1 No three bedroom detached house

Land to the rear of 20 and 22 Broadmark Lane Rustington

Thank you for your internet representation made on 5th September 2013 which has been recorded as '**an objection**' with the comments as follows:

DRAWING TITLE
PROPOSED ELEVATIONS AND
STREET ELEVATION

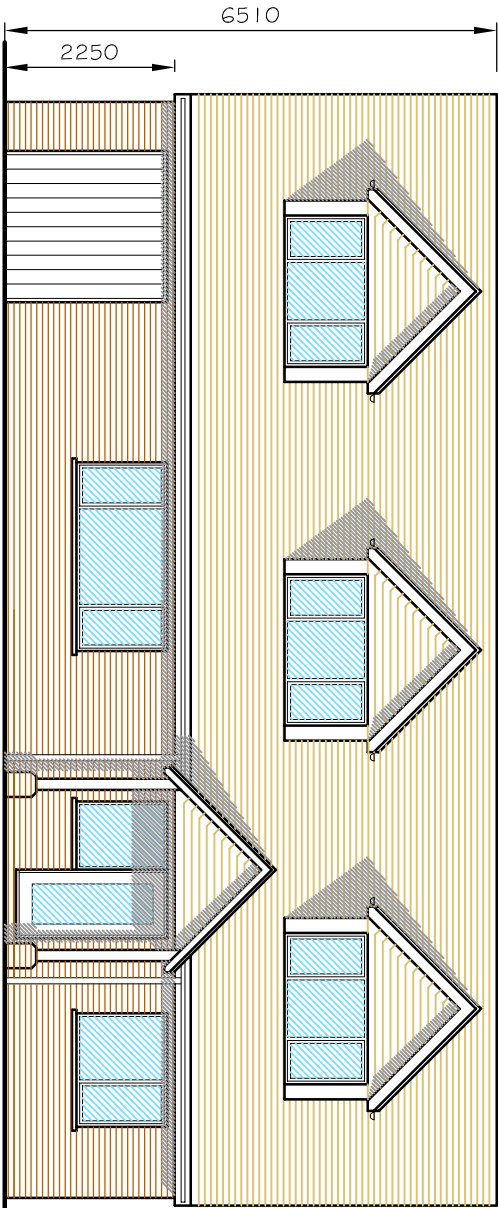
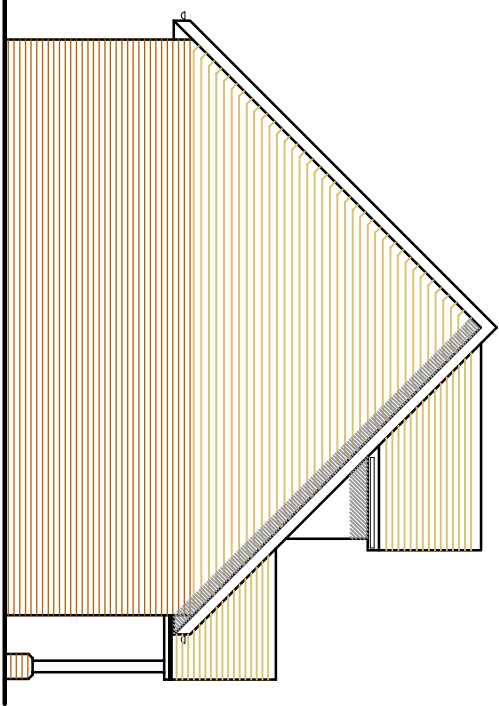
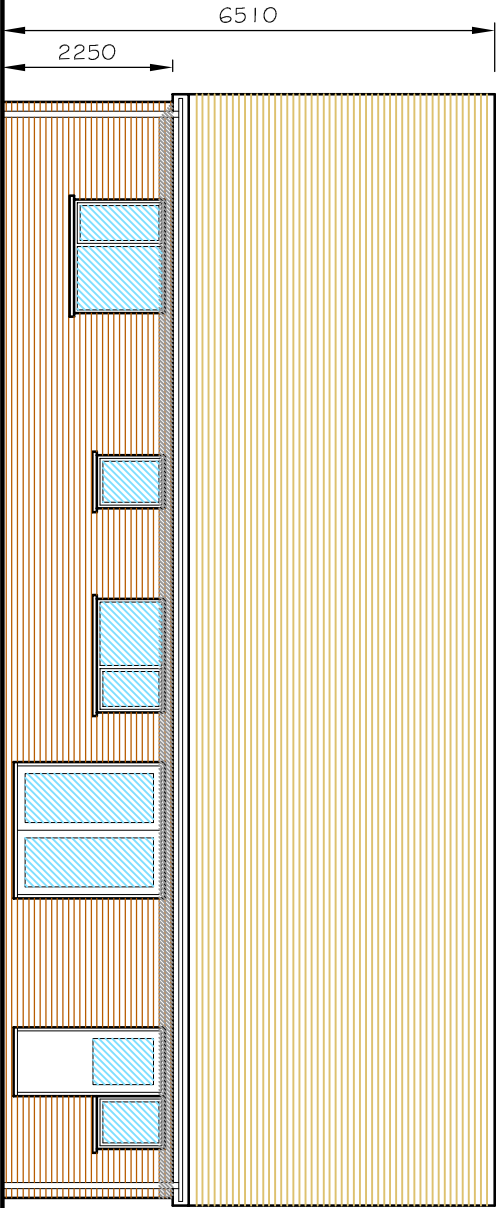
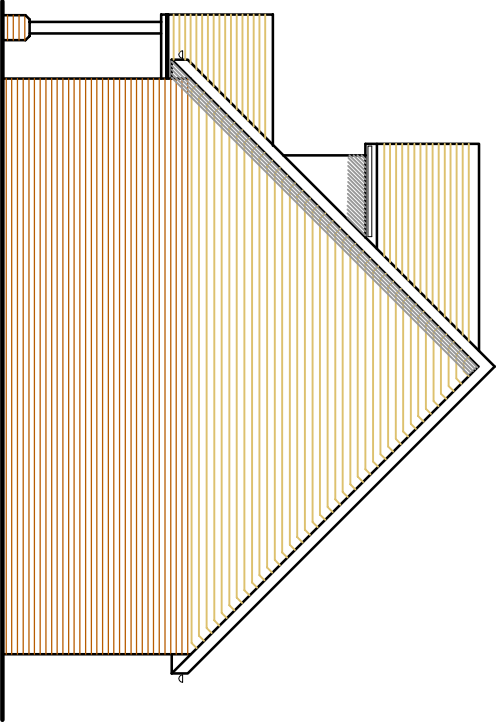
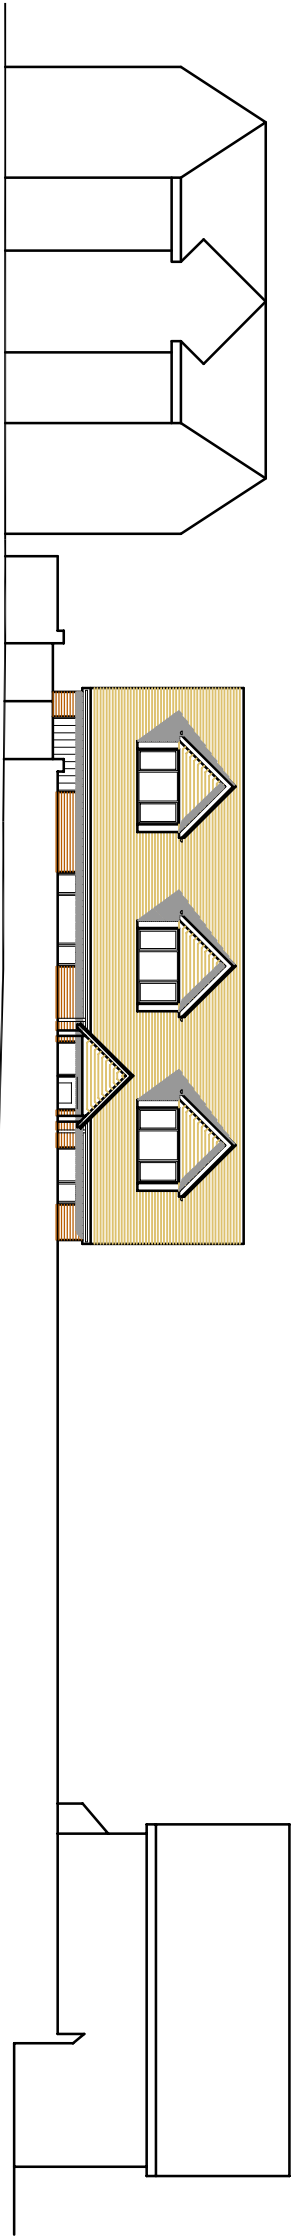
- *Out of scale for the plot of land and will border existing neighbours too closely.*
- *A two story building will over-shadow adjacent properties and gardens at various times during the day, particularly when the sun is in the south and west, by blocking natural daylight.*

- *The visual impact will not be in keeping with existing properties, many of which appear to have been built in the 20s and 30s*
- *Development of this site will increase the density of residential accommodation within the existing settlement leading to additional vehicles, possible noise and disturbance.*

DRAWING TITLE
SITE LOCATION AND LAYOUT PLANS

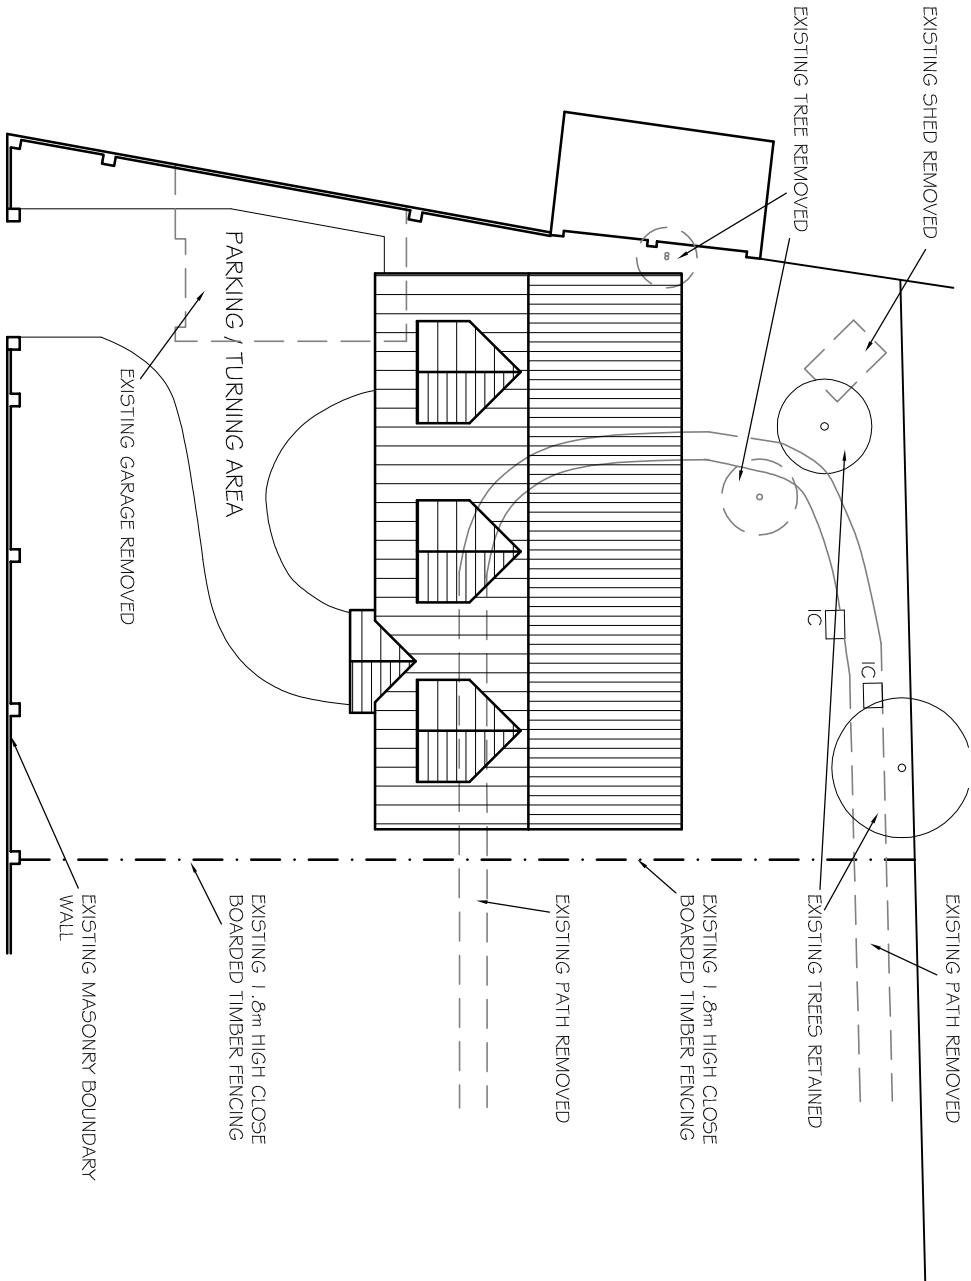
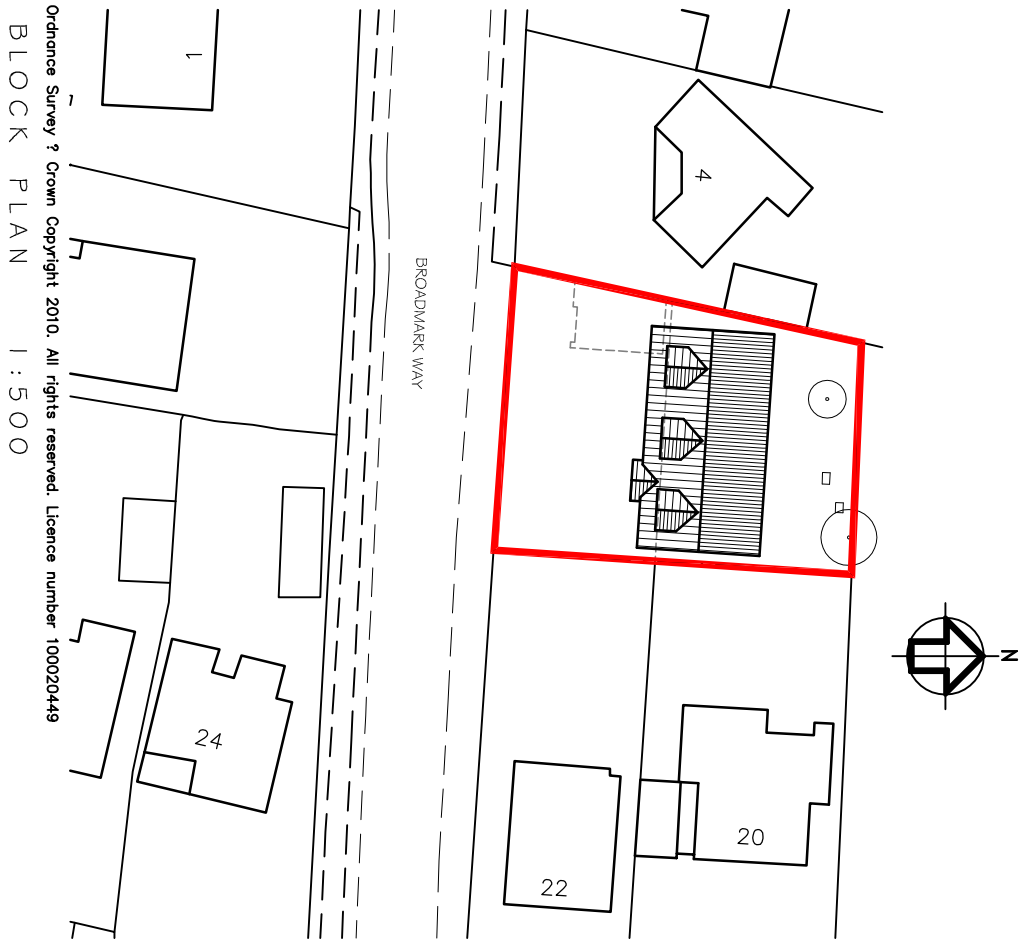
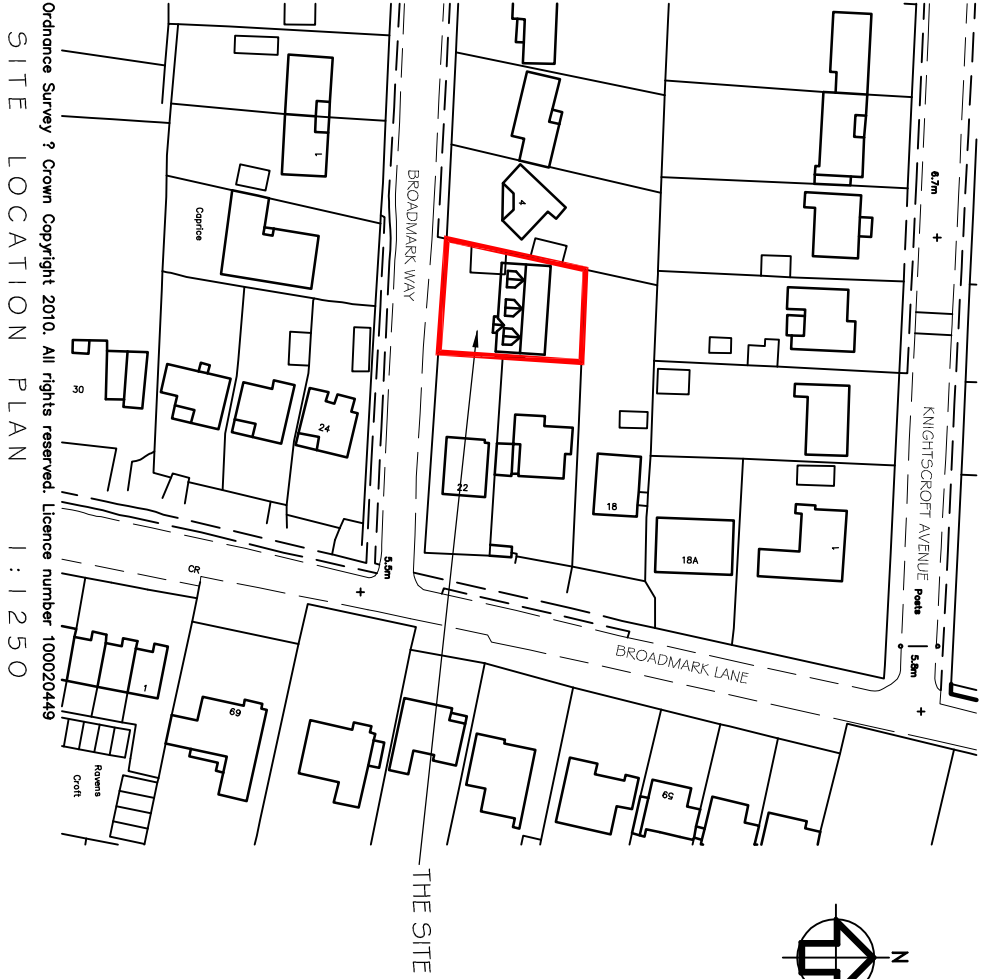
- *The access to the proposed building is from a residential road with a no street parking policy. The plans indicate a small amount of off-street parking for a proposed home that could house 6-7 adults.*

- *The removal of trees and vegetation from the plot, a haven for urban wildlife, particularly house sparrows, toads and bumble-bees will adversely impact on the environment.*
